Please see our comments below, re Villa Farm variation to plans

Ref.2024/91089

## Spey

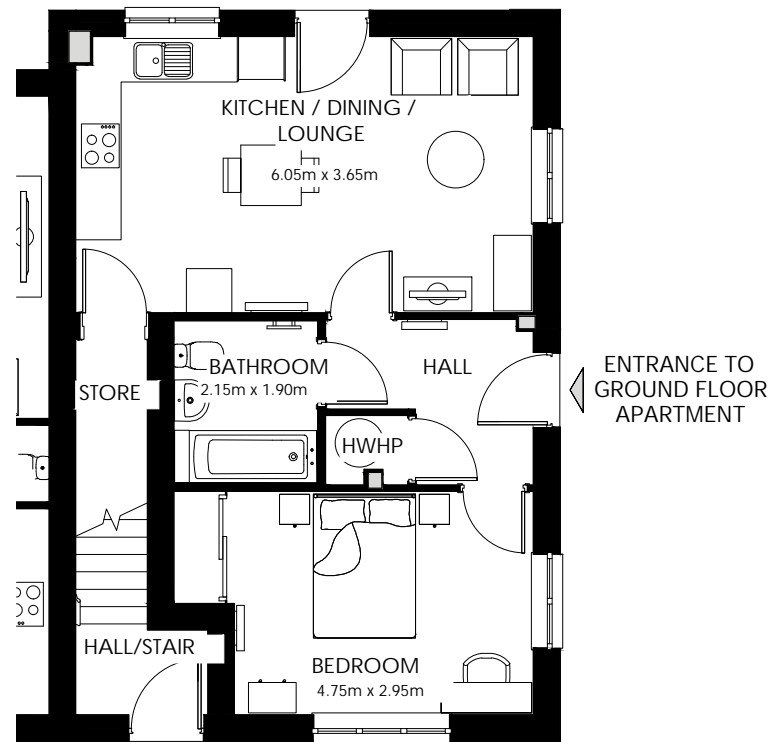
It was and still is unclear from the information provided what the proposed houses would look like as no street scenes are provided. It seems Redrow do not care enough to even show complete elevations of some of the blocks of houses including and particularly the terraced properties abutting our garden. This seems if not cynical then at the least unfair.

What we perceive as proposed is, a blank wall of brickwork very close to

TITLE: PROPOSED BOUNDARY TREATMENT PLAN

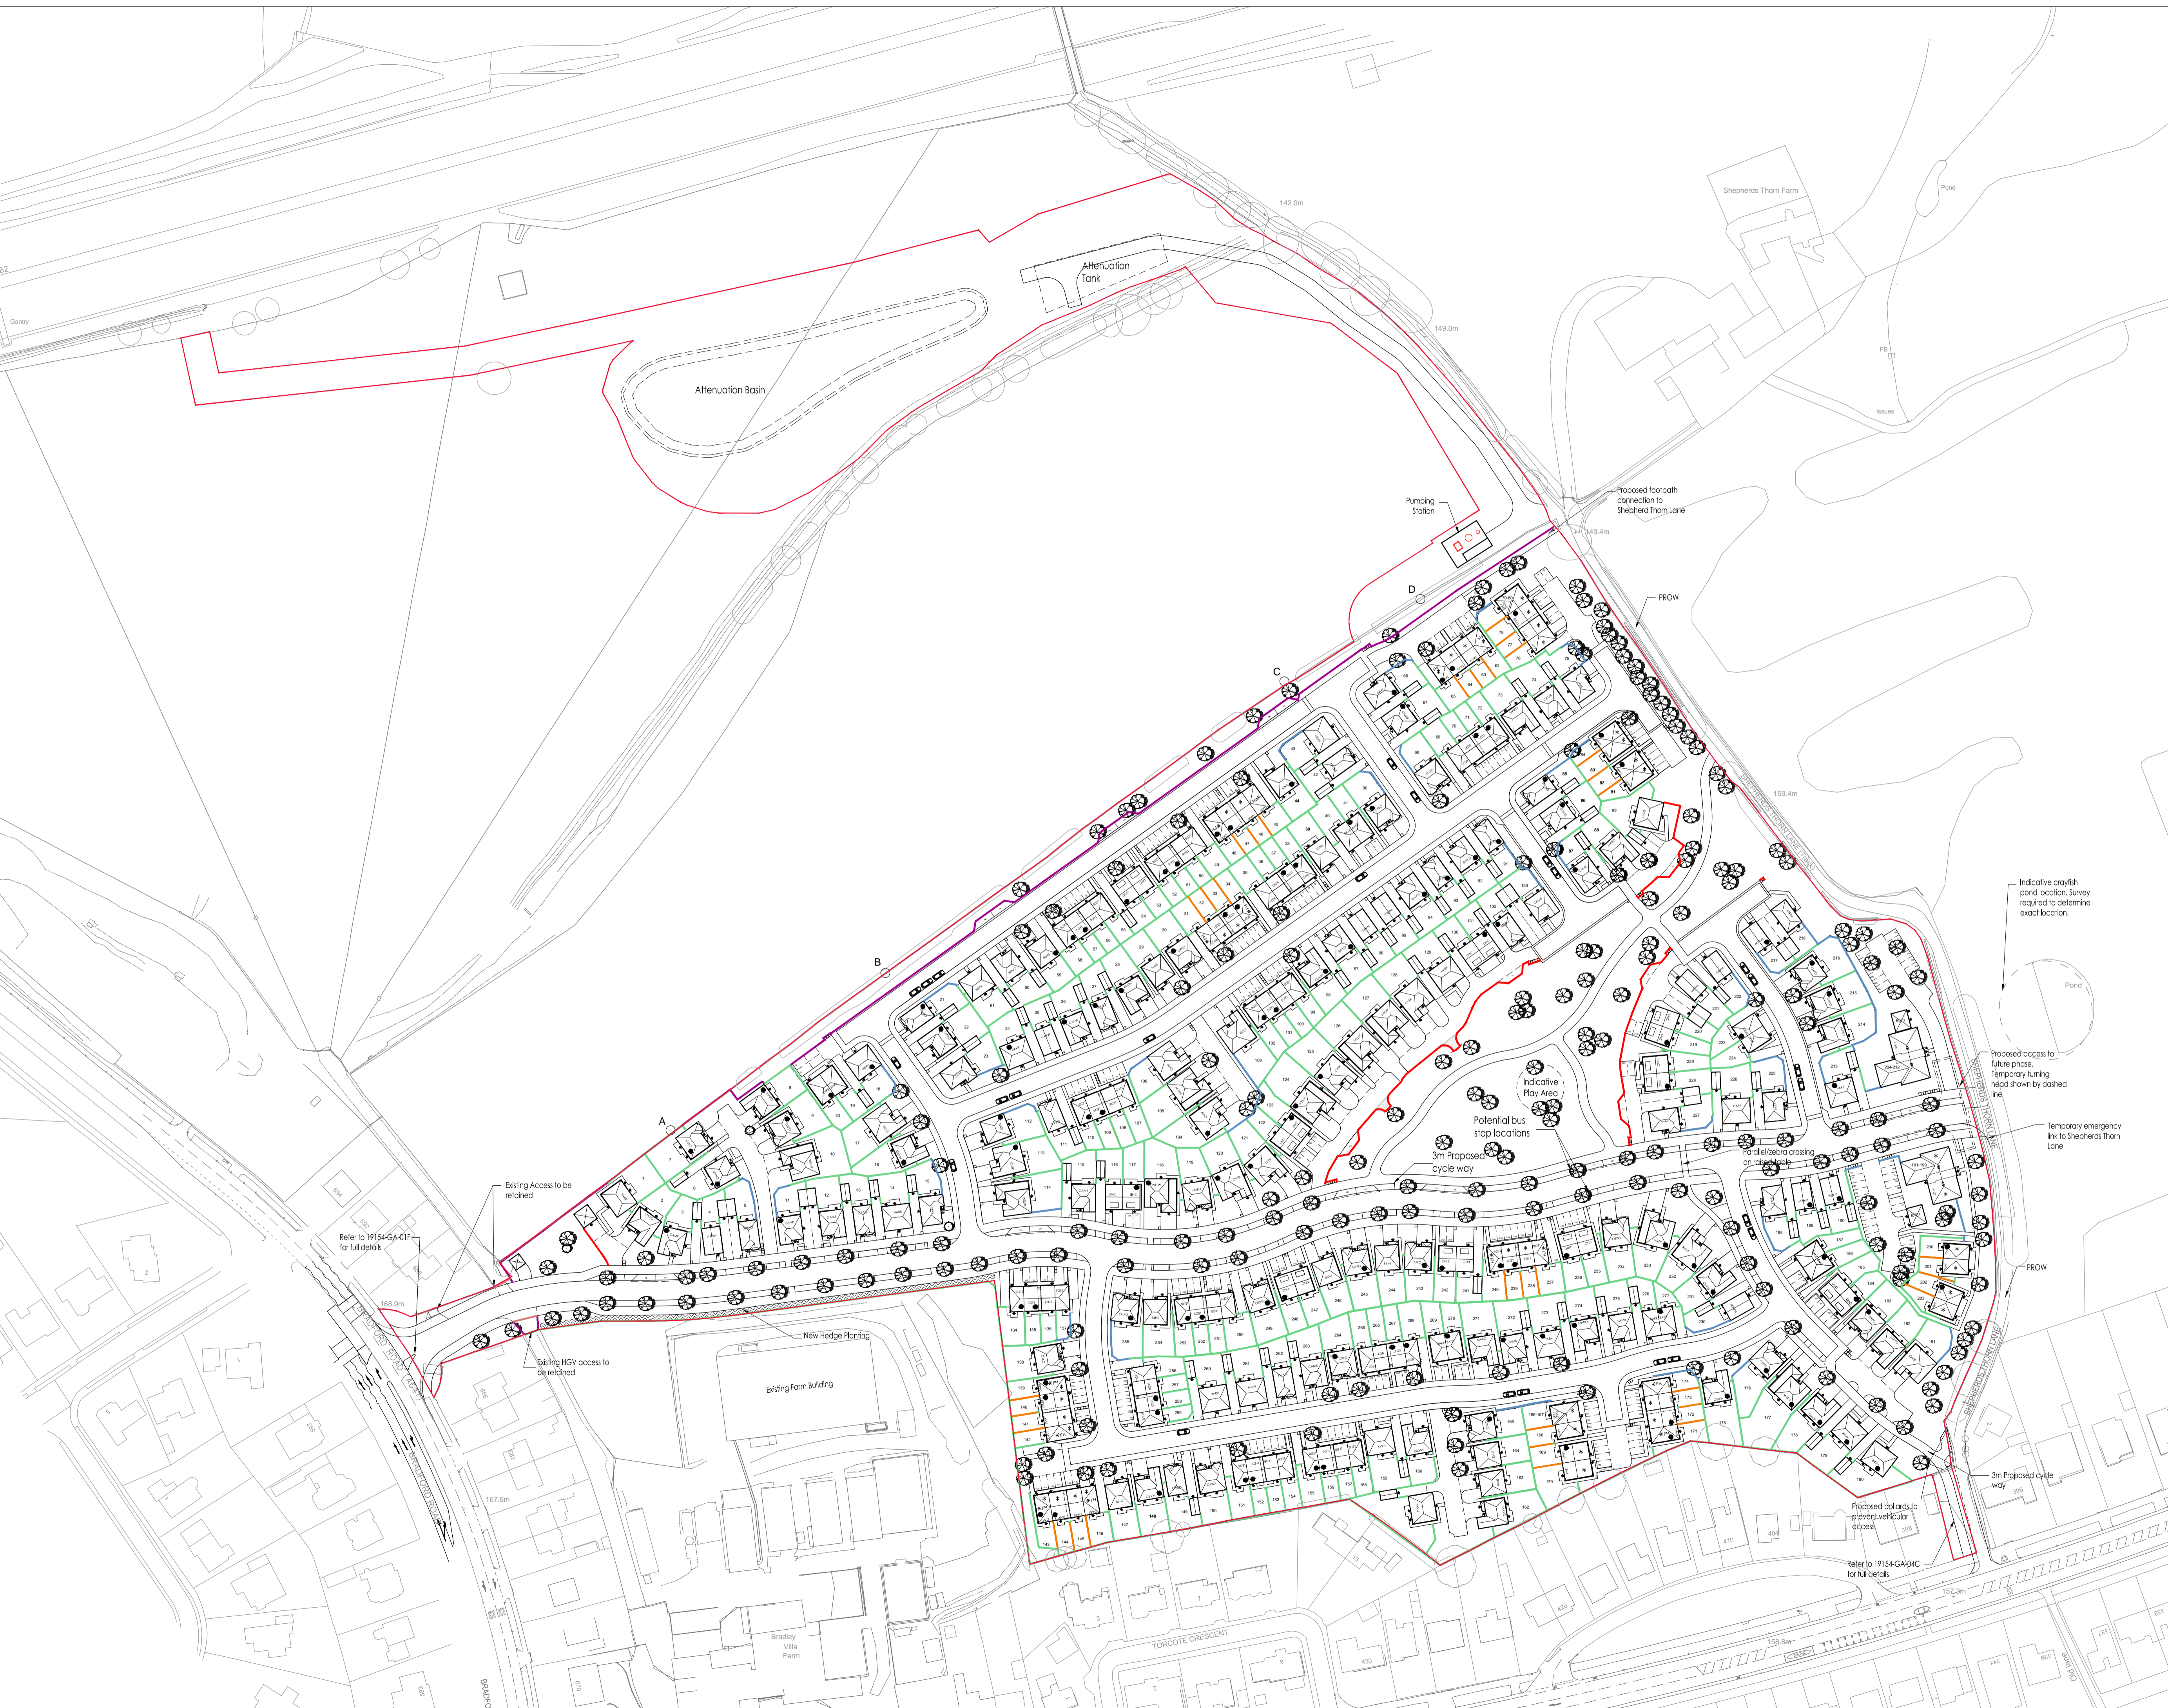
We are still concerned about the impact on wildlife by the destruction of existing vegetation on the southern boundary of the site which will inevitably ensue from the crude and thoughtless introduction of the proposed fencing.

No consideration has been made for a landscape buffer along this boundary affecting all the properties on Bradley Road. What landscape which will exist is just in small areas where they haven't managed to place a road, house or garden.
